Recommendation Report for Planning Permission

REF NO: FP/30/19/PL

LOCATION: 10 South Road
Felpham
PO22 8EF

PROPOSAL: Demolition of chalet & erection of 1 No. 4 bedroom chalet (resubmission following FP/234/17/PL)

Site plan
10 South Road
Felpham
Scale 1:500

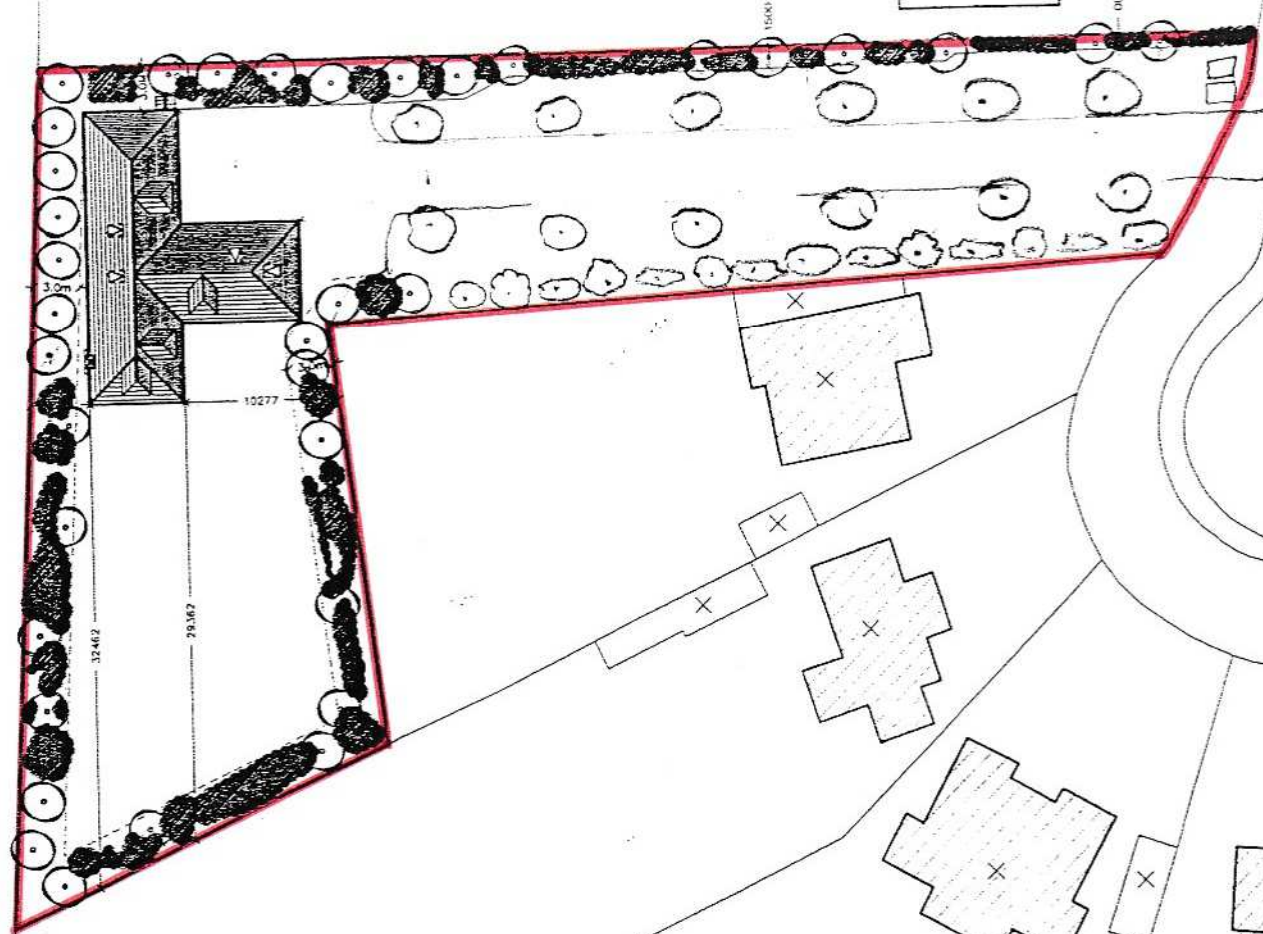
- The applicant is proposing to relocate the existing access onto South Road; however this has not been clearly demonstrated on the proposed plans and does not demonstrate details of the closure of the existing access.
- The WSCC car parking demand calculator expects that a minimum of 3 parking spaces would be required for a dwelling of this size and location. As the plan shows, there is more than adequate parking on site, including the garage to accommodate the habitants. The proposed garage meets minimum internal specifications of 3 x 6m as set out in Manual for Streets (MfS).
- The Local Highway Authority (LHA) does not consider that this proposal would have 'severe' impact on the operation of the Highway network, therefore is not contrary to the National Planning Policy Framework (paragraph 109), and that there are no transport grounds to resist the proposal.

The large trees to the rear of the building are shown as being retained on the proposed plan. Although, given the location of the dwelling it is considered likely they would be lost during or before the development. Although not protected by order, the trees are of significance in terms of visual amenity, visible from south road and the public footpath to the west (rear) of the site and this is a consideration for the purposes of ESD9 (ESD6 of Emerged Plan) of the Felpham NDP. However it would be not a reason to refuse the application.

Elevations

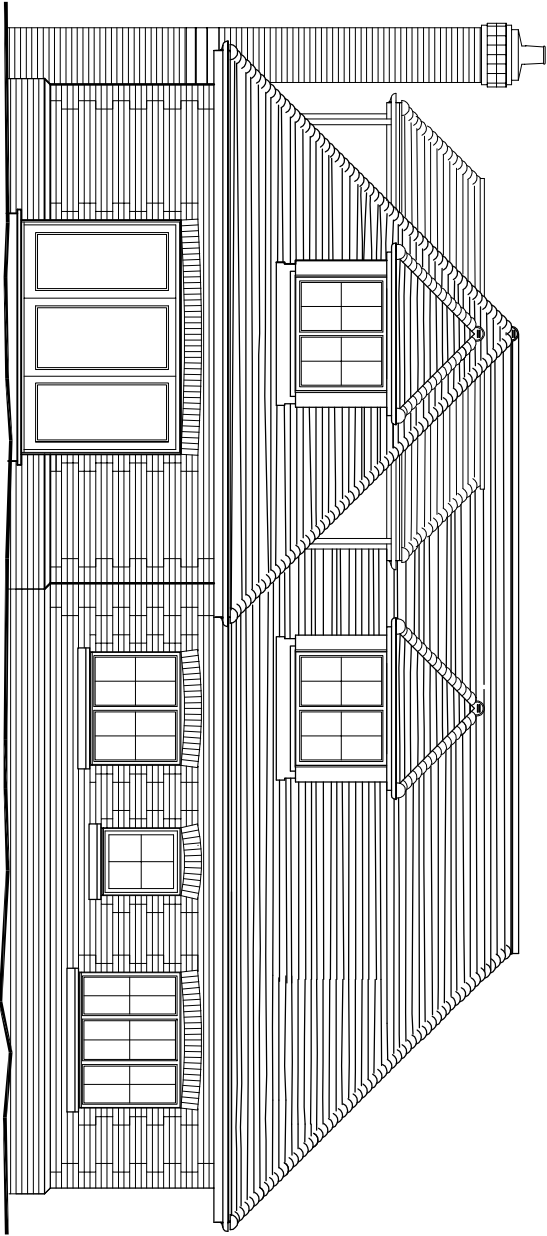
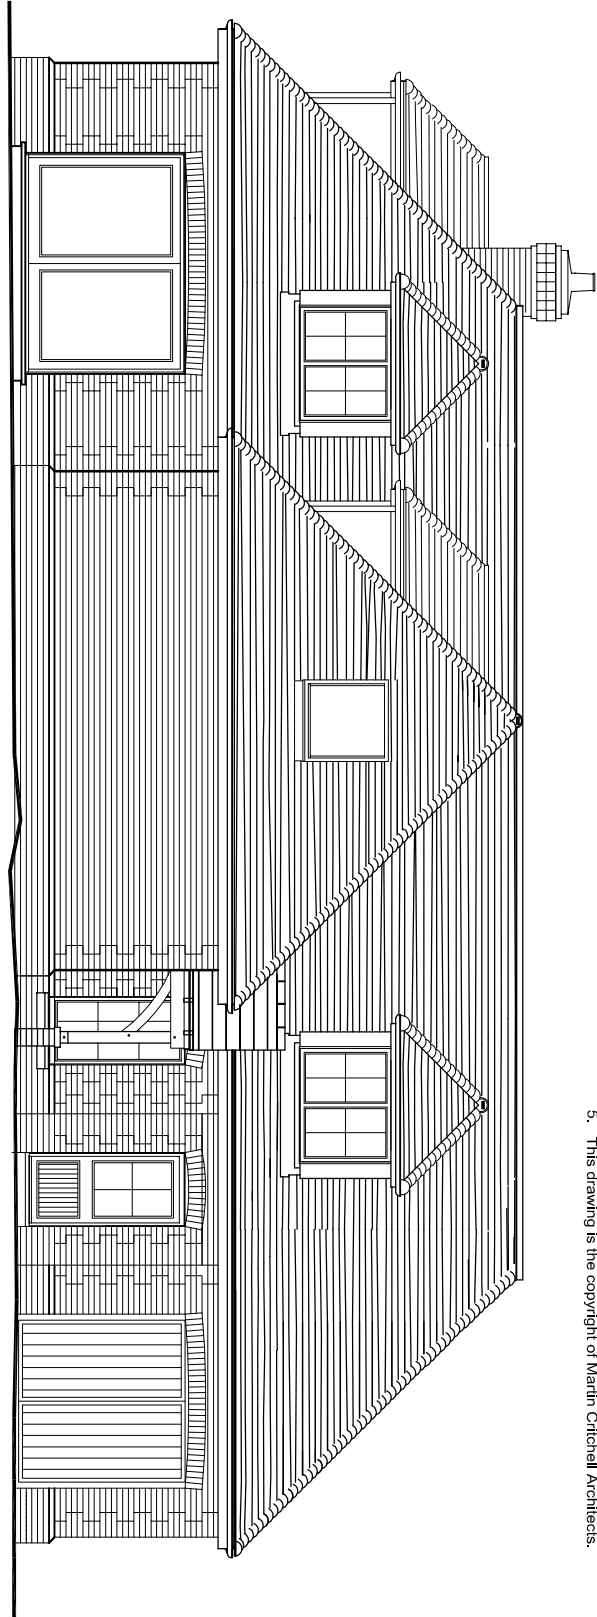
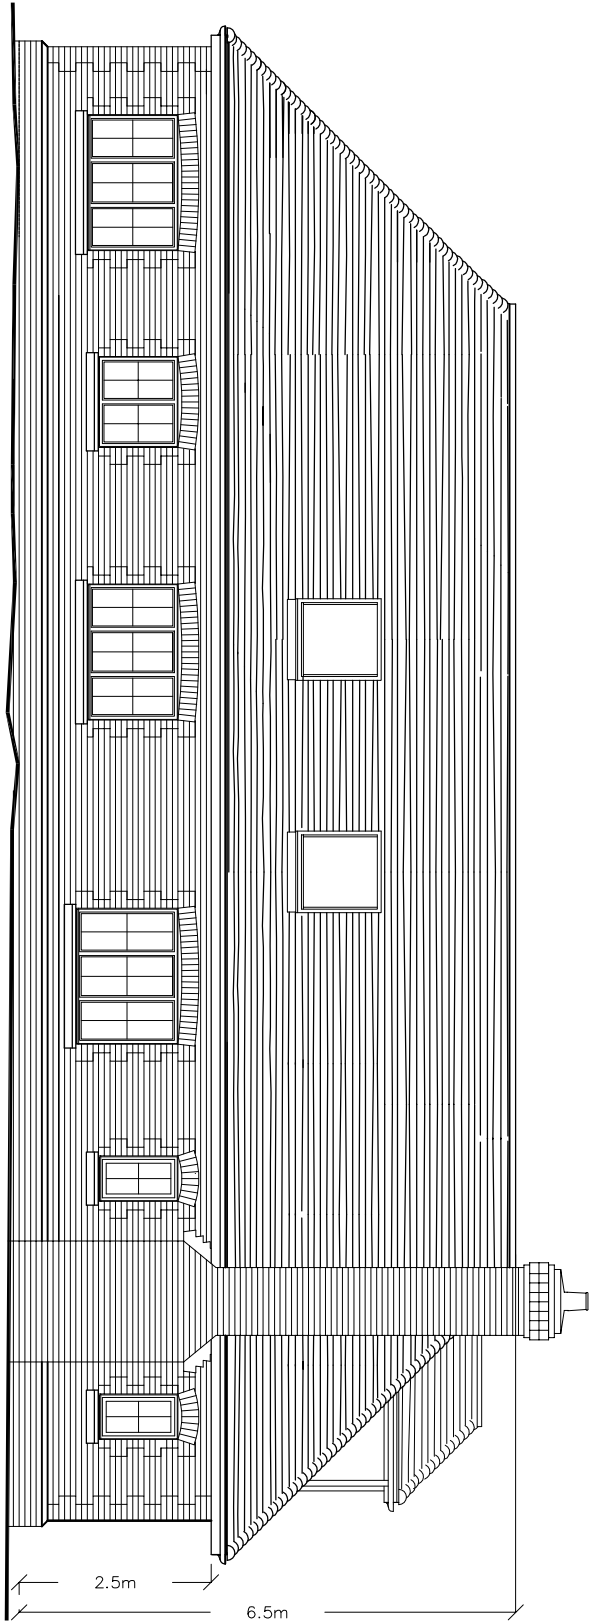
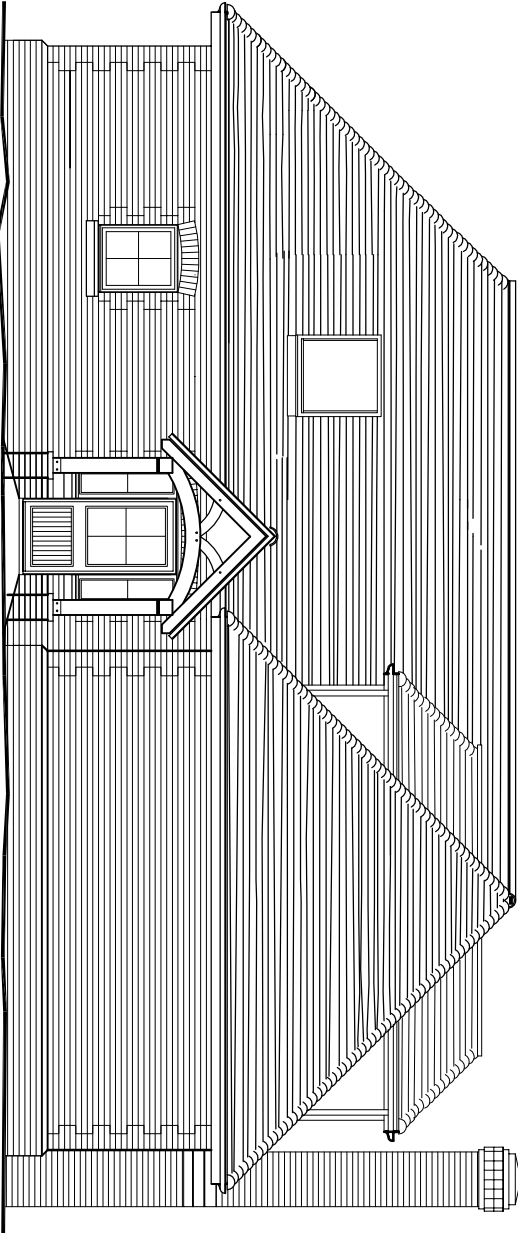
Notwithstanding the above, submitted drawings are inaccurate, the proposed elevations are not matching with the proposed roof plan, the street scene is misleading, failing to show the relationship between neighbouring properties.

"SKETCH" PROPOSED STREET SCENE

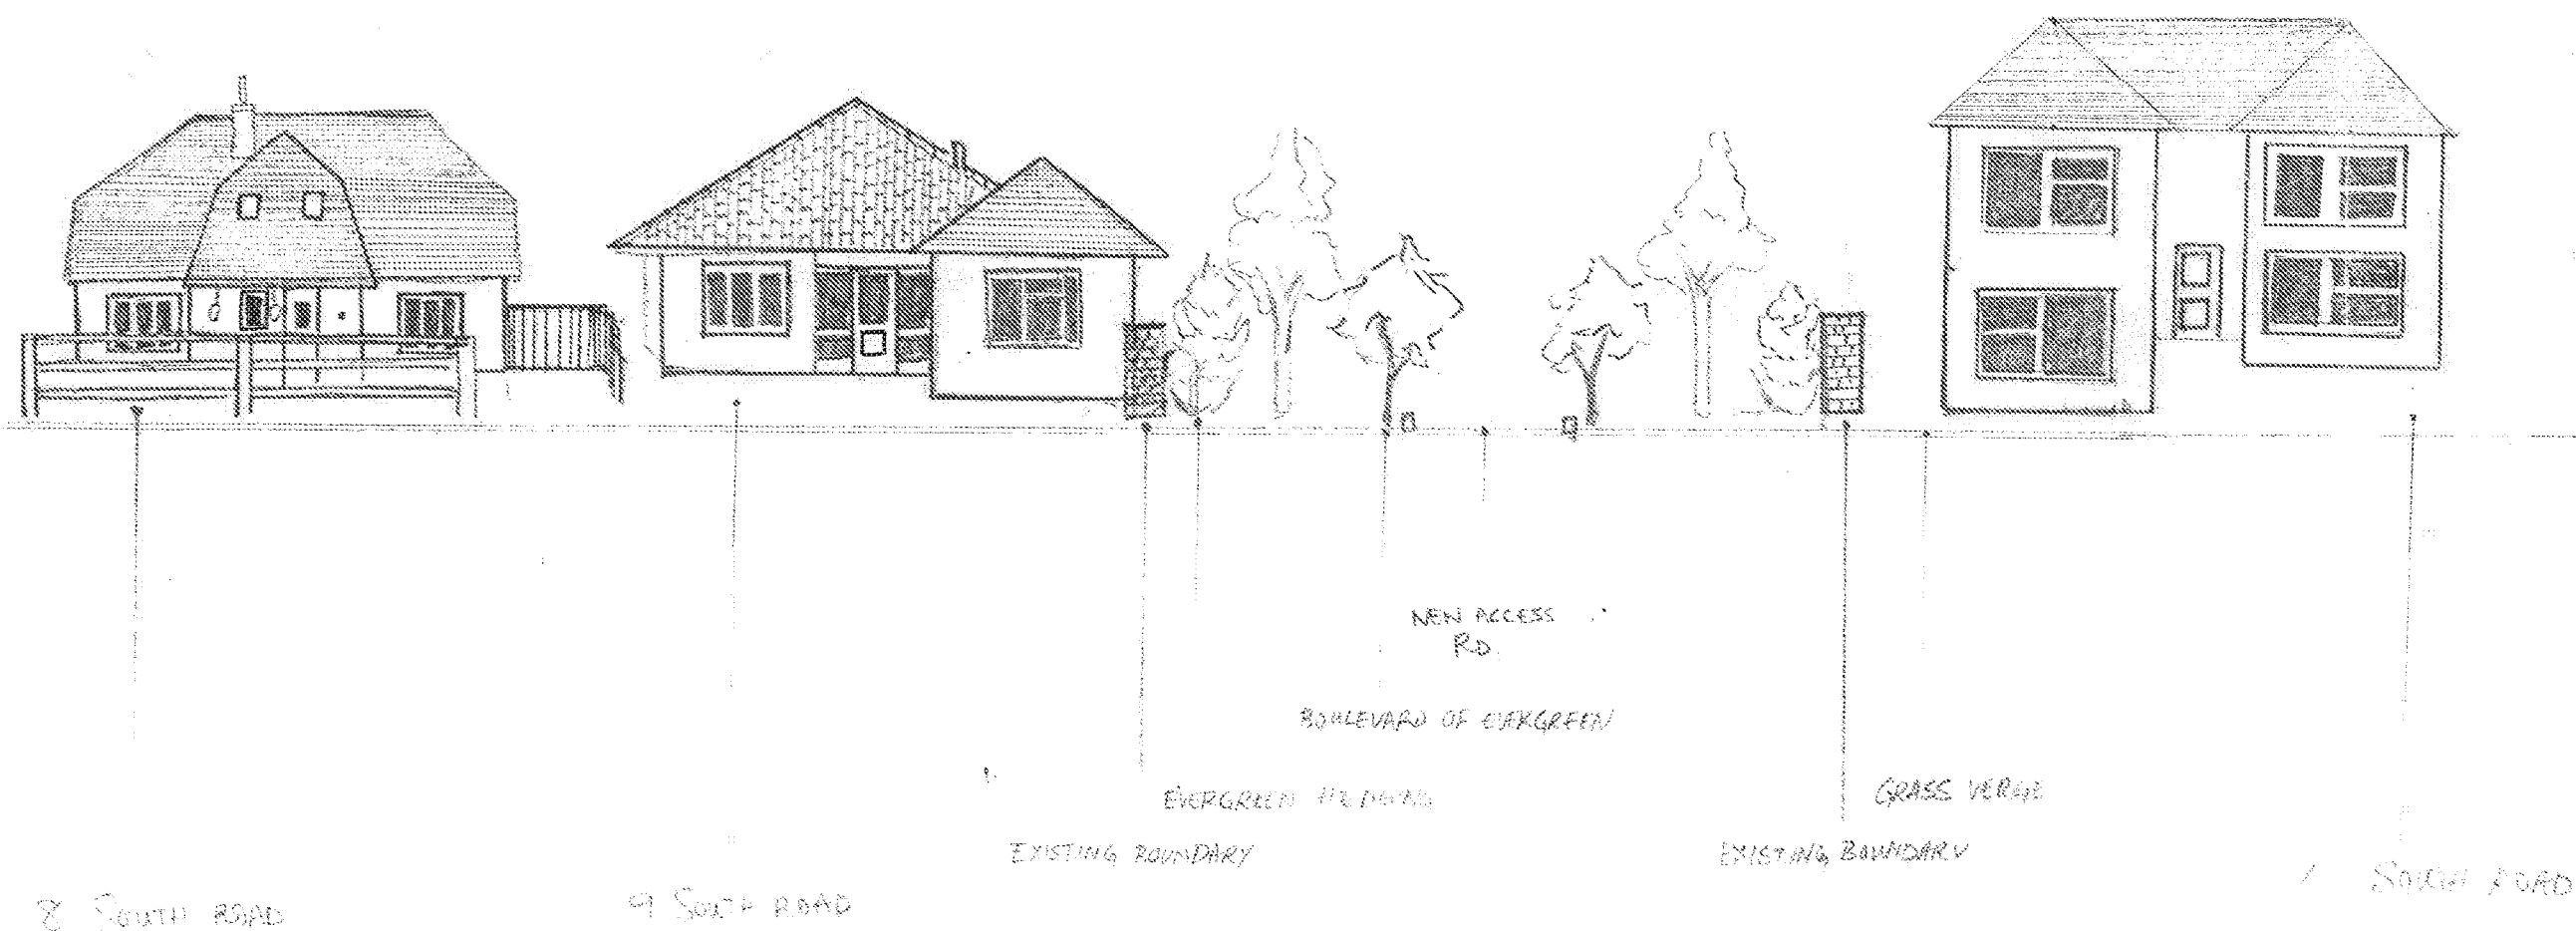
Whilst the dwelling would not be out of keeping with the varied design of dwellings in the cul-de-sac and wider area, the new dwelling would be sited far behind the building line in the western corner of the rear garden. This would be significantly at odds with prevailing pattern of development in the area which consists of centrally positioned detached properties within generous plots with relatively low boundaries fronting to the cul-de-sac with its open quality, exposing the properties in slightly raising landscape in the shoe horse shape. The demolition of an existing dwelling No10 in order to create access to proposed dwelling in the rear garden would create an incongruous gap within the area of a subtle symmetry. The new access road hemmed with trees/bushes and facilitated with a lay-by for large delivery vehicles and an air-conditioned shed for deliveries would disrupt the urban pattern of the area. What is more, the site of No10 is the widest one within a cul-de-sac. Submitted 'proposed street scene is more confusing than helping to understand the outcome of the proposed.
